MECKLENBURG COUNTY  
Park and Recreation Department

MEMORANDUM

**RE:** Rezoning Petition #2021-125 – Caldwell Park

Rezoning Site Plan

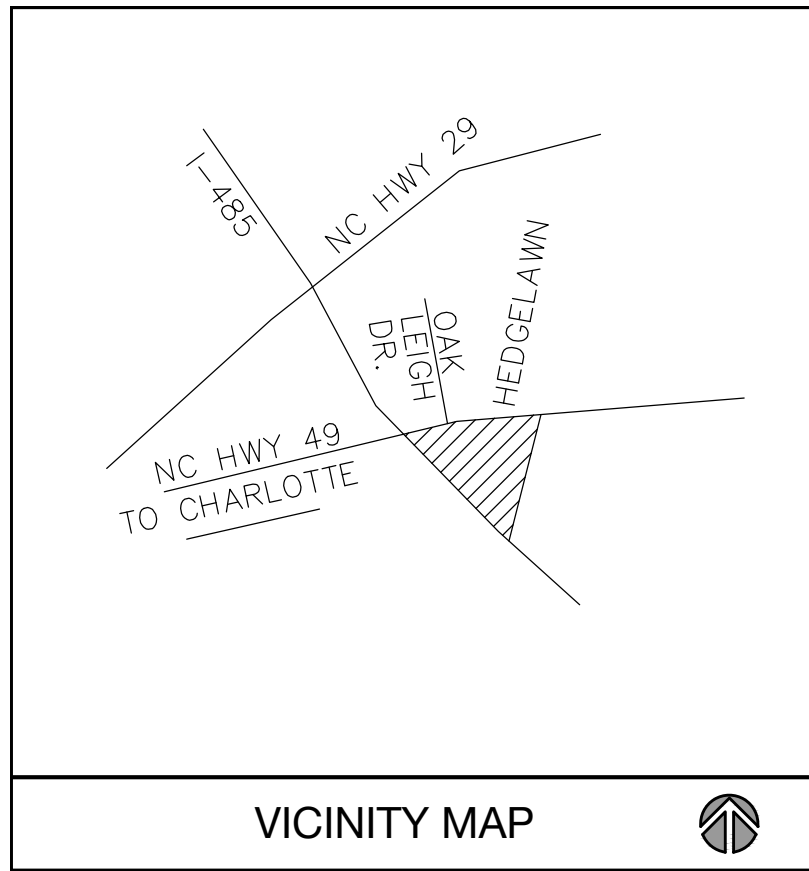
MCPR requests the petitioner dedicate and convey or provide a greenway and storm water easement of the same area to Mecklenburg County - the 100' SWIM Buffer and the FEMA floodplain of Back Creek, plus the Duke Utility easement north of Back Creek. MCPR also requests a minimum of 100' wide easement between the dedicated greenway parcel/easement and the development street ROW. Trail dedication can overlap with tree save areas. This parcel is on the MCPR Greenway Master Plan.

Additionally, MCPR requests the petitioner dedicate the 7.5 acres of land south of Back Creek and adjacent to Abercromby Street and I-485 for future park development. Park dedication shall not be encumbered by tree save.
